# CITY OF PORTLAND BUILDING PERMIT

This is to certify that DAVID M DEBARTOLO-STONE Located At 7 CANDLEWYCK RD

Job ID: 2012-06-4249-ALTR

has permission to Repair Existing back porch

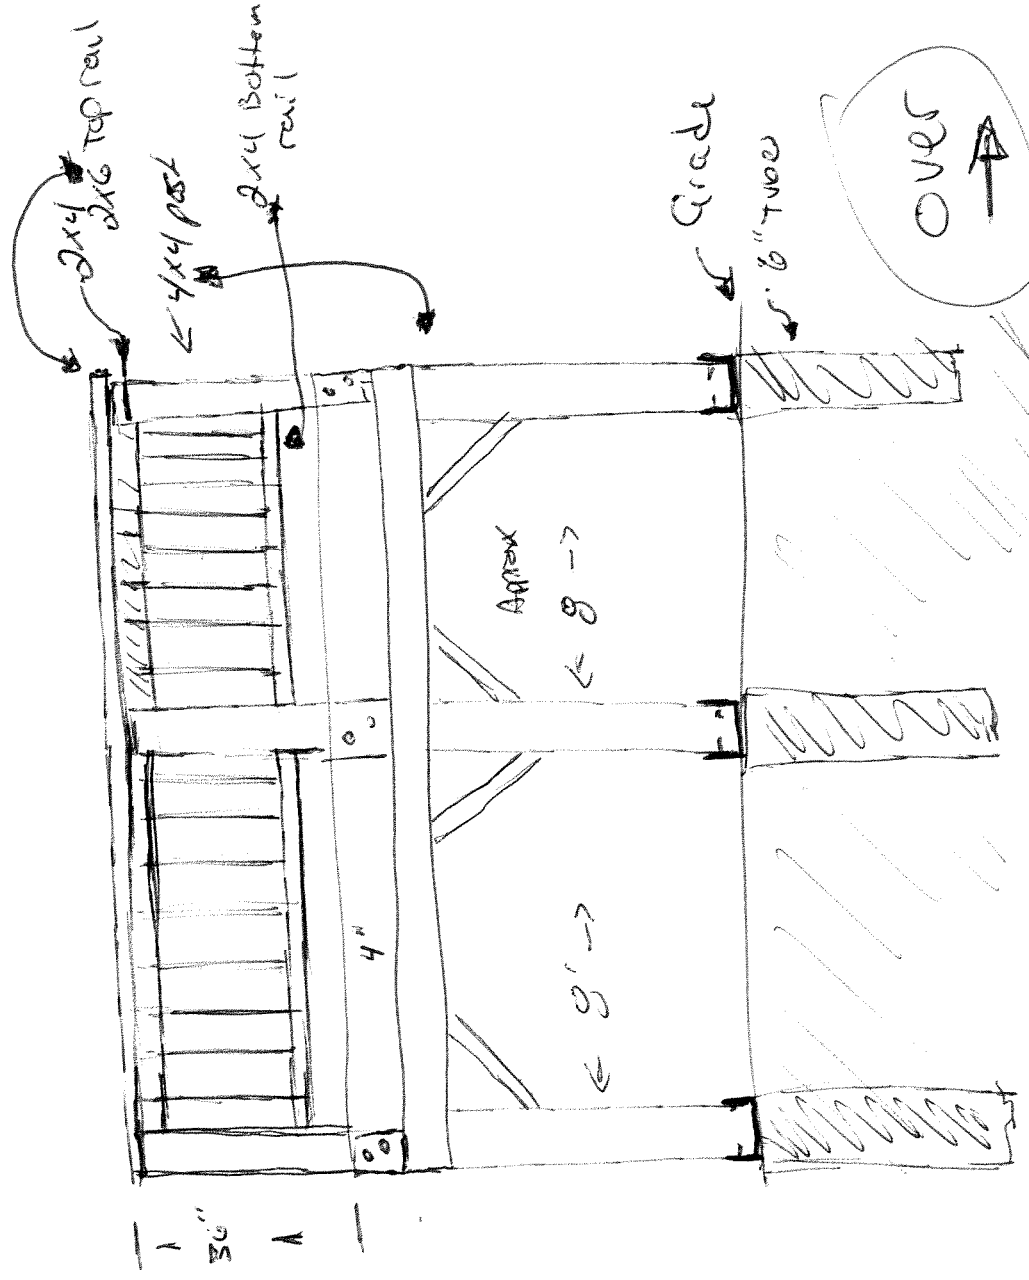
The existing deck shall be inspected for adequate fasteners and bearing for spans, and modifications may be required

8-8-12 DWM Final Provide lateral support per IRC 502.2.2, Handrail to be 34"-38" above nosing, Guardrail at steps to be 34" min, Guardrail at deck to be 36" min, Openings to be <4"

8-23-12 GF ① RAILS CORRECTED

② DECK EXISTING - LATERAL NOT REQUIRED THRU
